Your ref:	The Craven Hotel Discharge o...	Please reply to:	Mr Joshua Wilson
Our ref:	23/08751/ADFULL	Tel No:	
		Fee Queries:	0207 641 6500;
		Email:	planningreception@westminster.gov.uk;
Andrew Trevillion Trevillion Architects Ltd 42 Prebend Gardens London W60XU United Kingdom		Incomplete Applications Town Planning & Building Control City of Westminster PO Box 732 Redhill, RH1 9FL	
			28 December 2023

Address: 10 - 11 Craven Terrace, London, W2 3QD,

Proposal: Details of how waste is going to be stored on the site and how materials for recycling will be stored separately, details of secure cycle storage for the hotel use and detailed drawings (elevations and detailed sections) showing details of the proposed windows pursuant to Condition 3,5 and 9 of planning permission dated 6th May 2014 (RN:13/12319/FULL),

Drawing Title  
**LOWER GROUND + GROUND  
FLOOR DISCHARGE OF  
CONDITIONS 3 + 5  
REF: 13/12319/FULL**

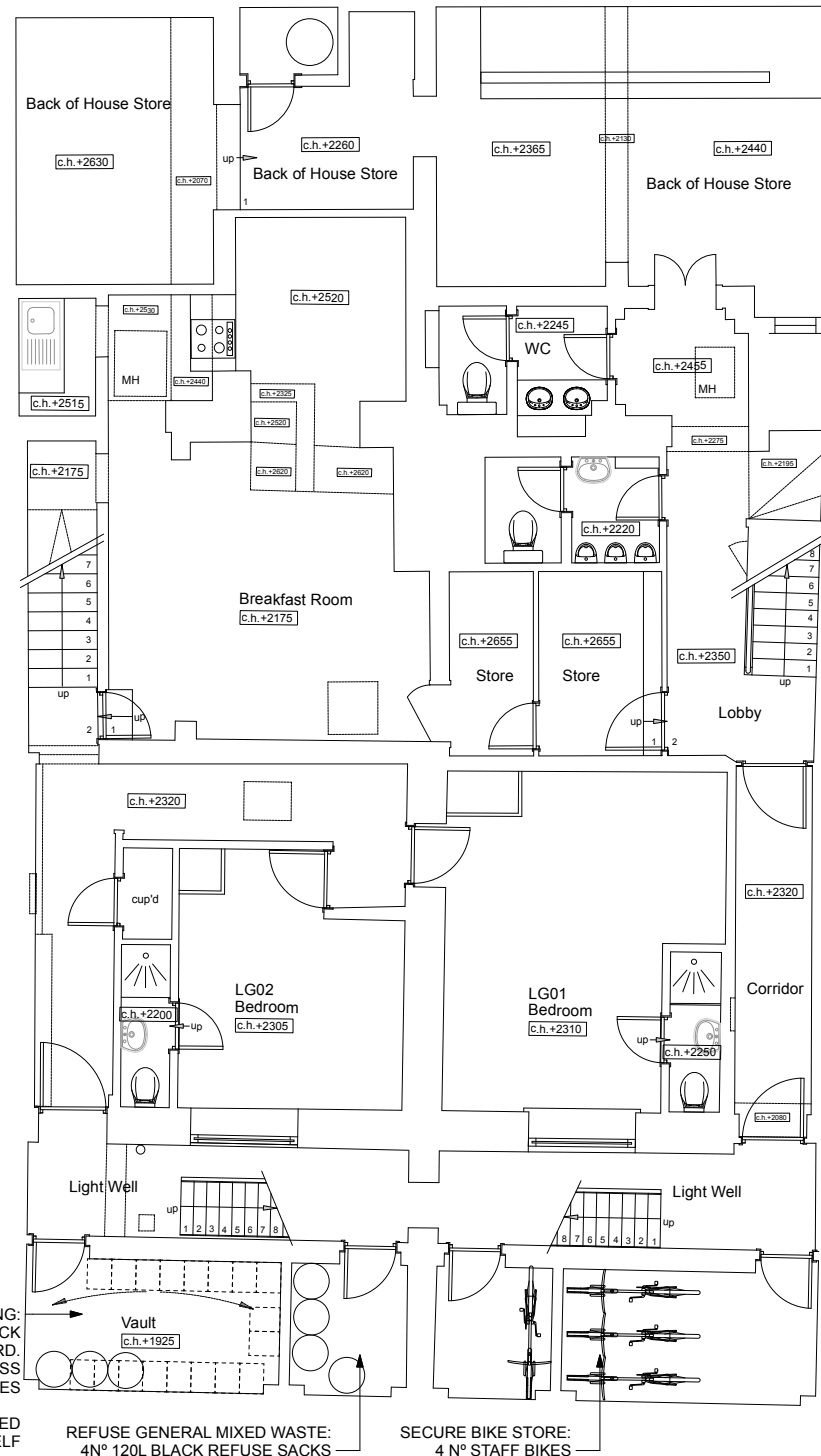
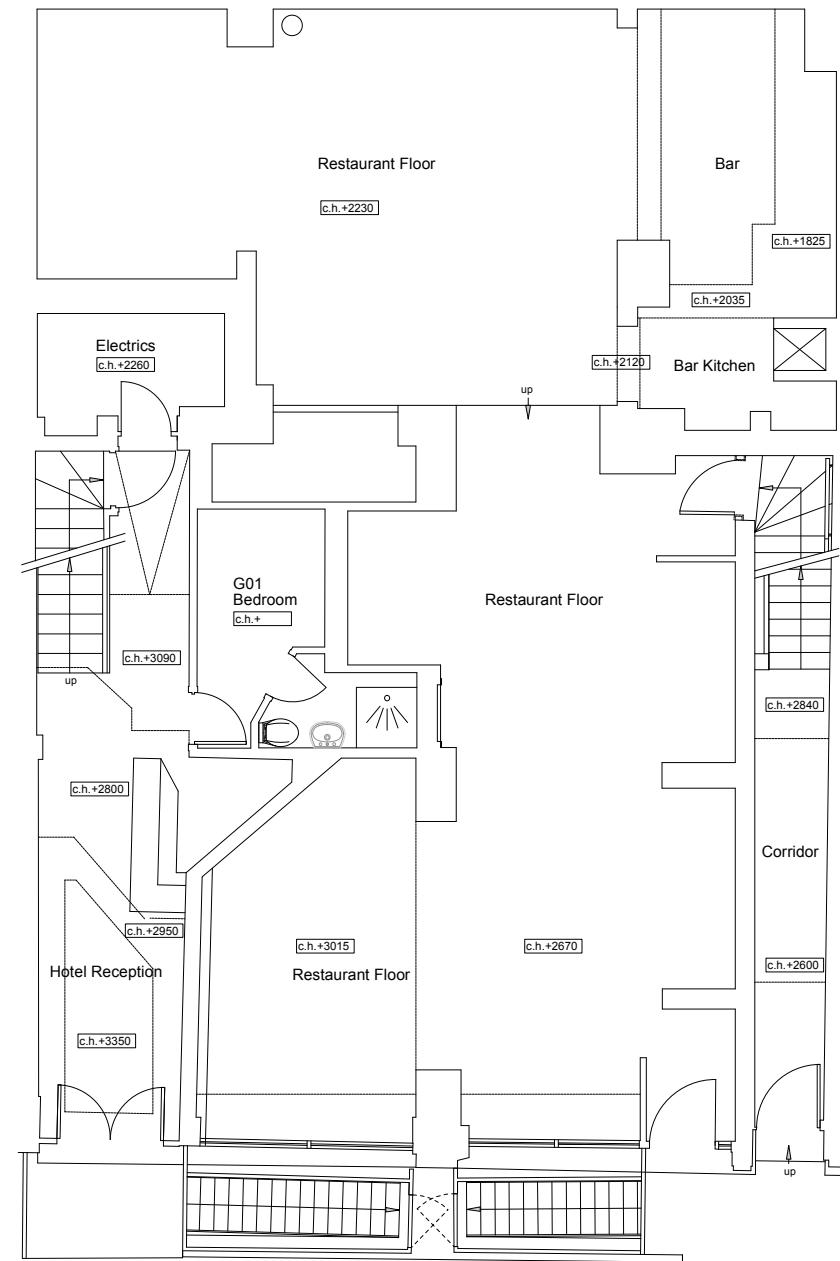
- 1 Please can you submit drawings in order to have sufficient details of waste storage.

To discharge the condition, you would need to submit a drawing to include the following:

- o Indicate area of waste storage on the drawing.
- o Confirmation of the bin capacities for each waste stream.
- o The bins should be labelled and indicated individually as R (for recyclable materials), O (for food waste) and W (for residual waste) on the drawing

TYPICAL DOUBLE GLAZED  
SASH WINDOW - DISCHARGE  
OF CONDITION 9

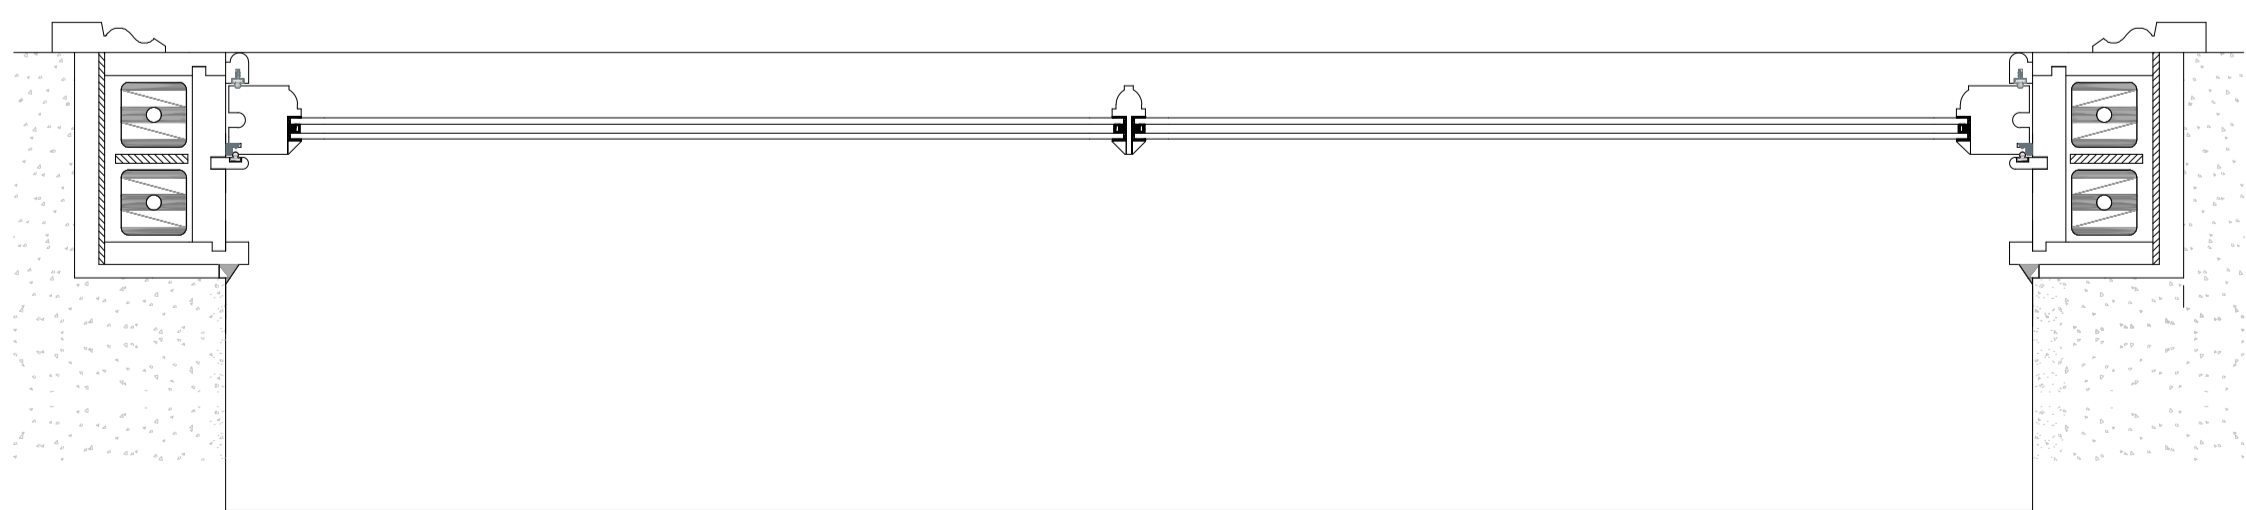
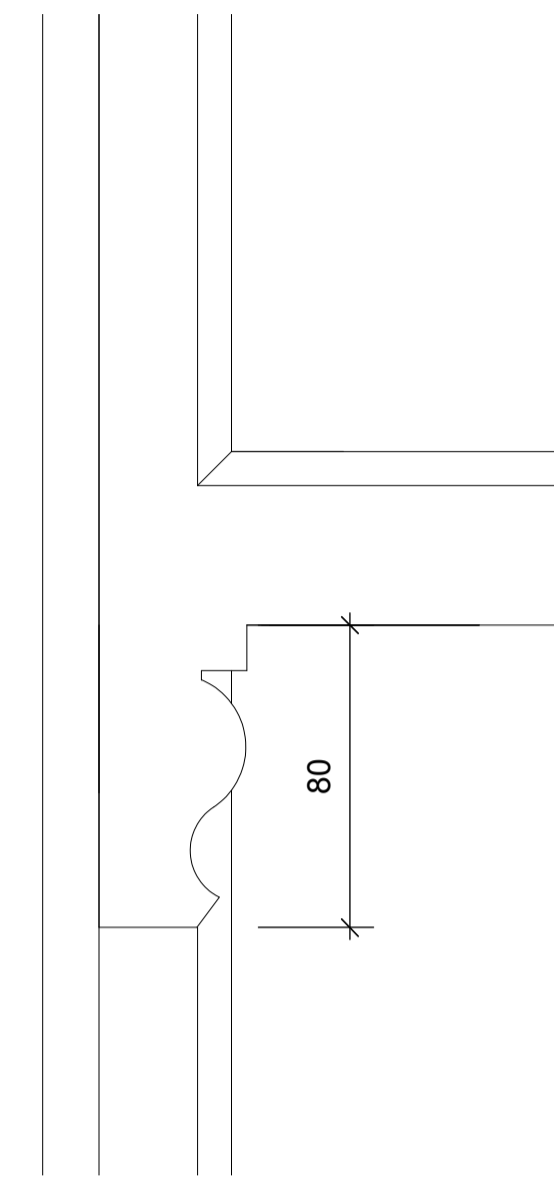
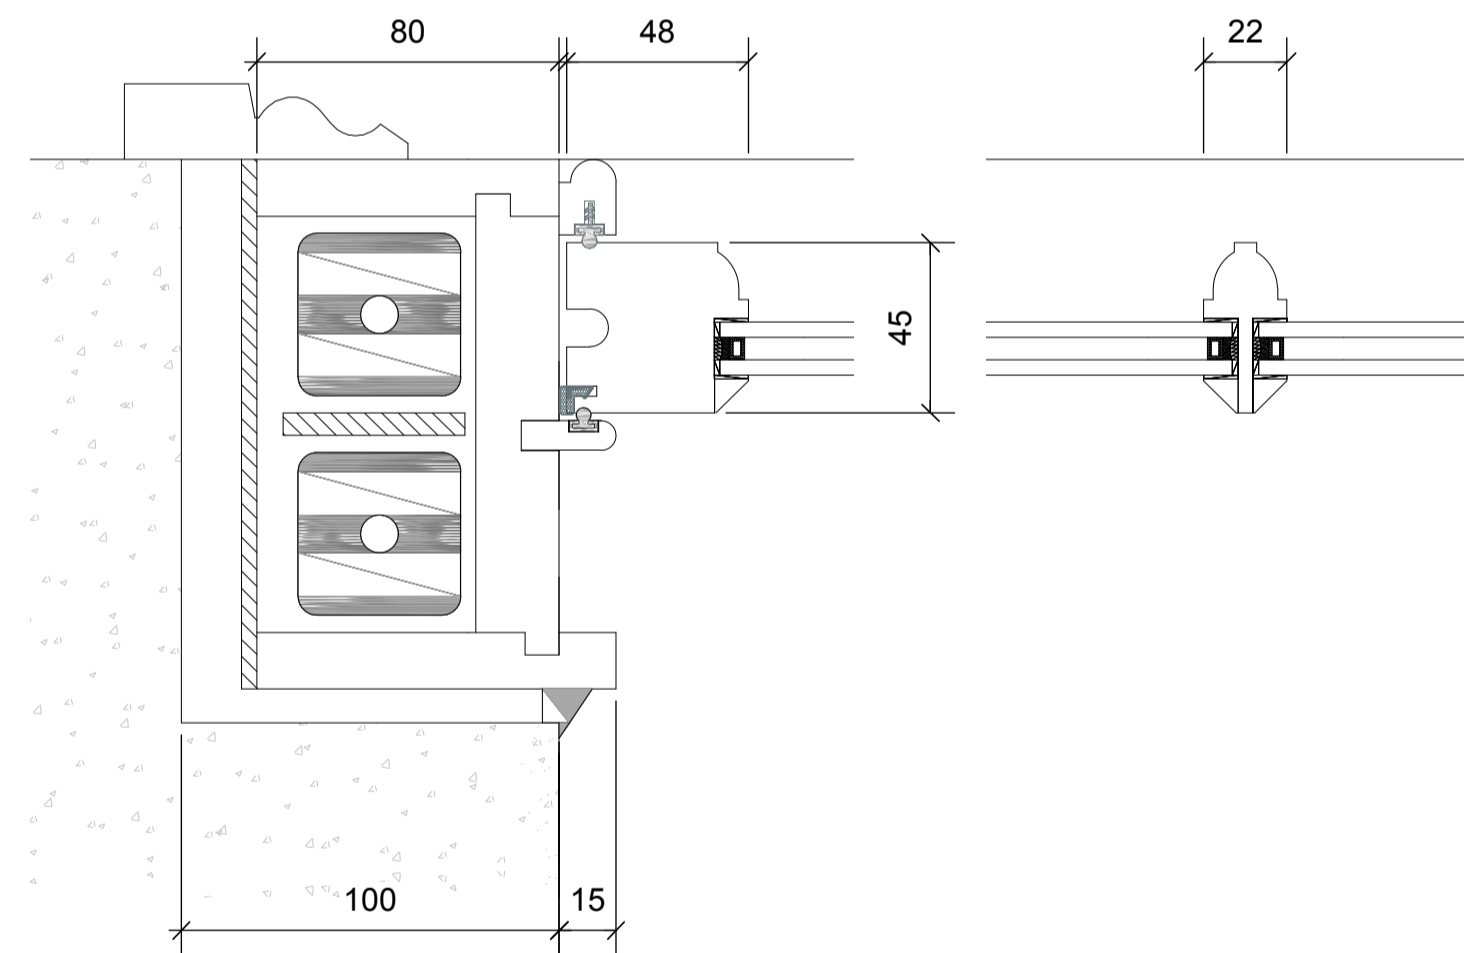
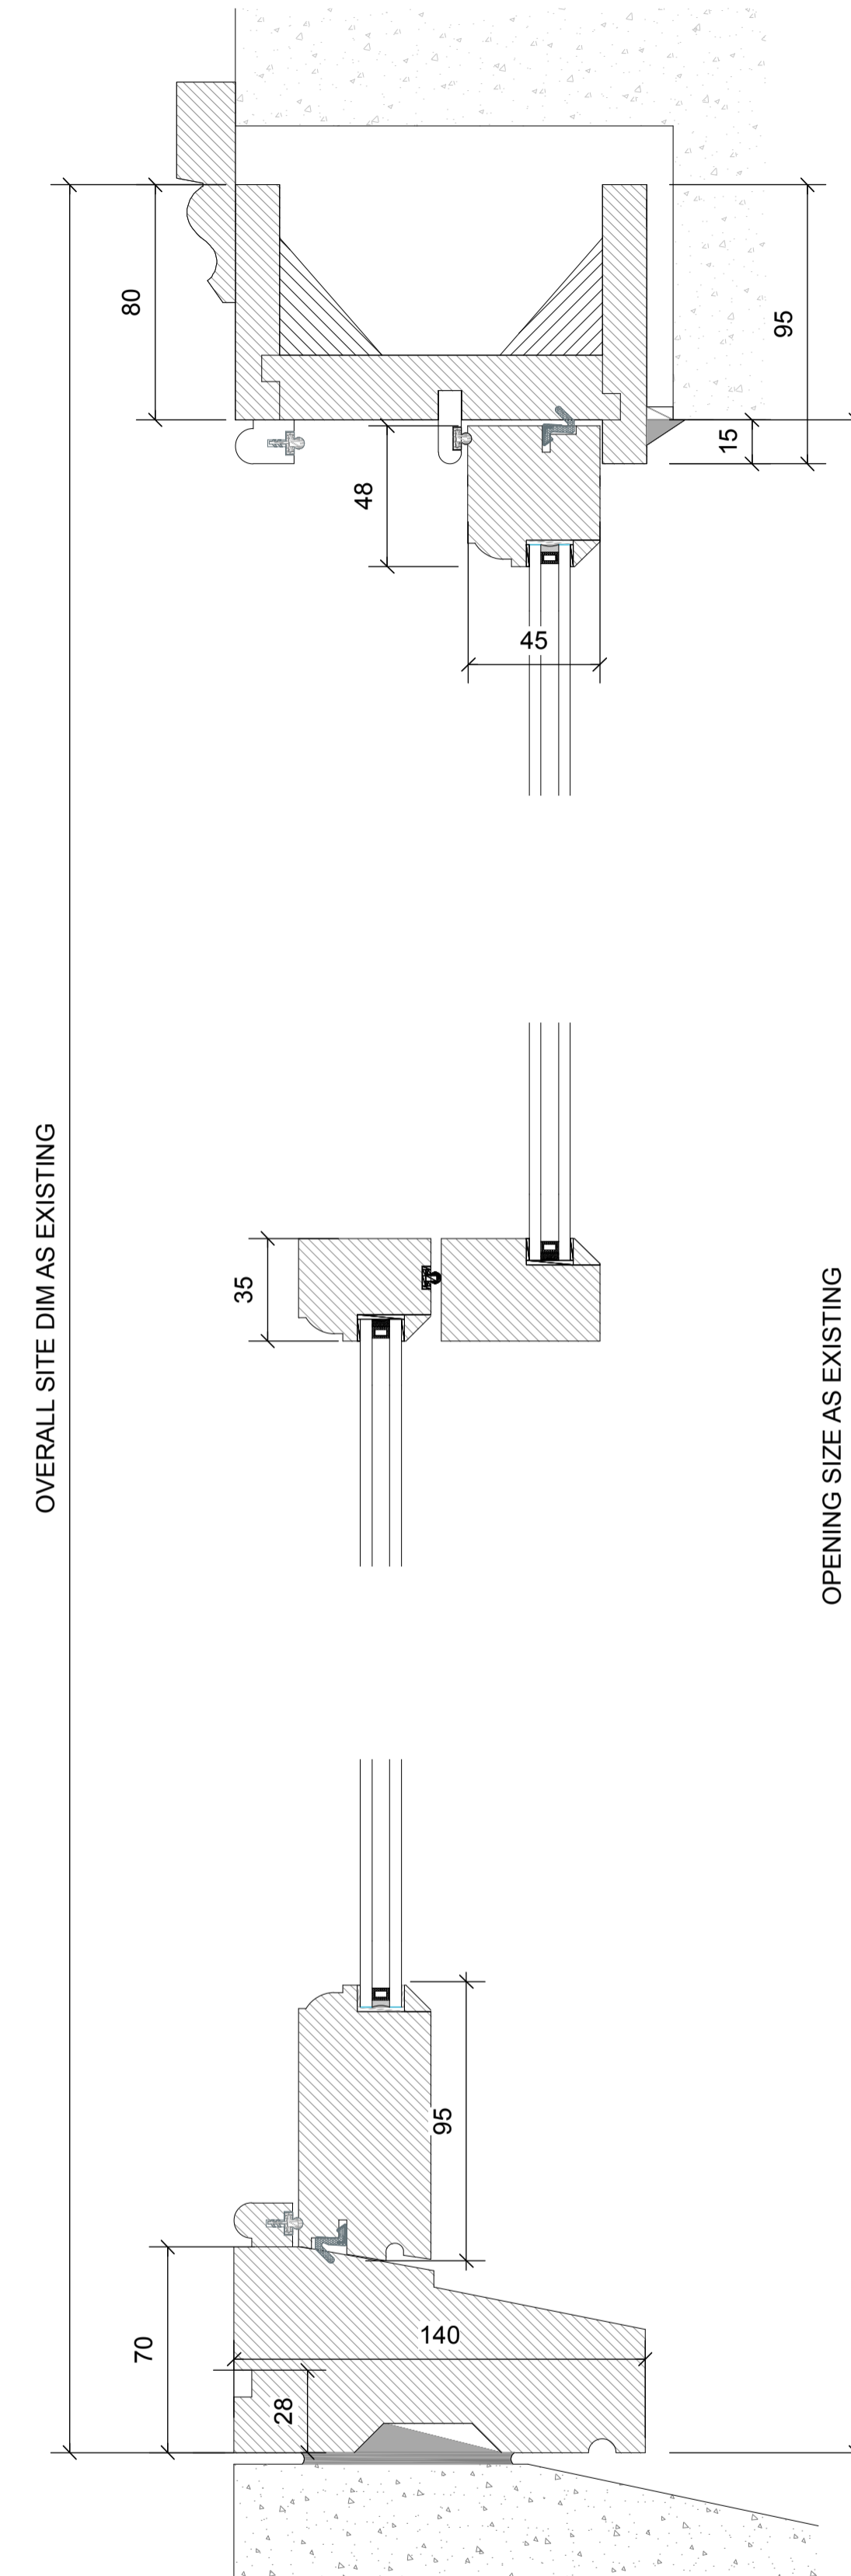
2 Some or all of the drawings submitted with your application do not include a scale bar, please amend the drawings to ensure all drawings include a scale bar.
